Our Ref: M/5/11/NMA - JAC

M/5/11/NMA - Application for a Non-Material Amendment following a grant of Planning Permission M/6/09 for installation of two roof lights on the rear elevation and three roof lights on the porch roof on the front elevation at 64 Sea Way, Middleton-on-Sea.

Drawing No: GRJ 64SW 202/B
Item: Revised Porch Roof
Three new porch rooflights
Scale: 1:100
Ref: NMA M/06/09

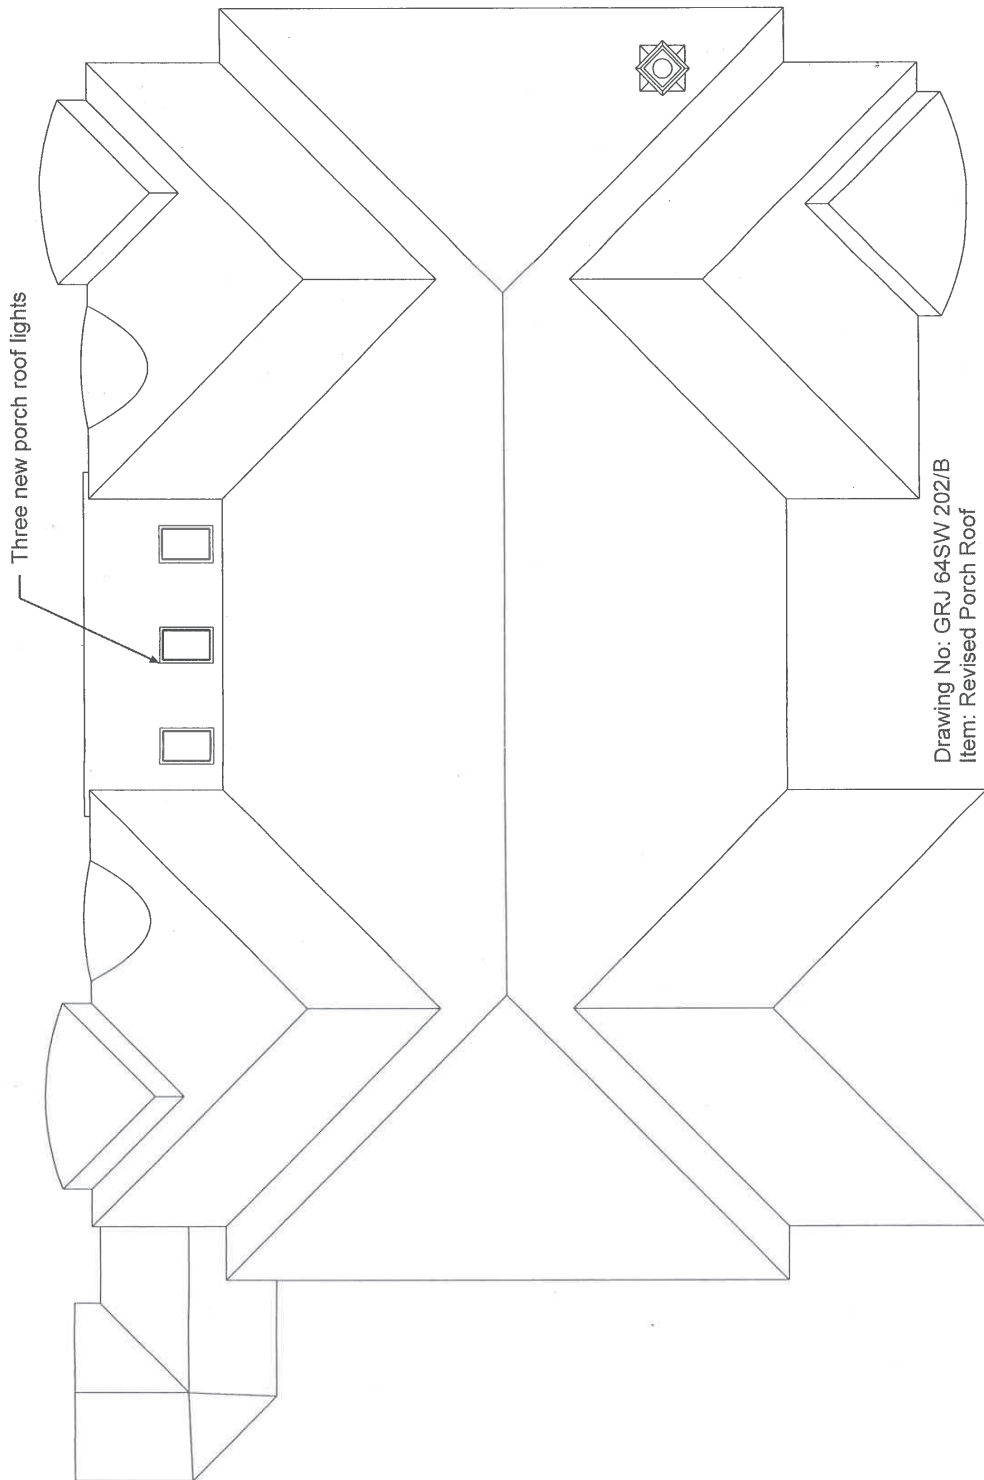
The amended porch design with three roof lights on the roof, the installation of two roof lights on the rear elevation and the deletion of one chimney stack can be accepted as a non-material amendment as shown on the submitted Drawings No. GRJ 64SW 201/A, GRJ 64SW 201/B and GRJ 64SW 202/B. This now becomes the approved plans for M/6/09.
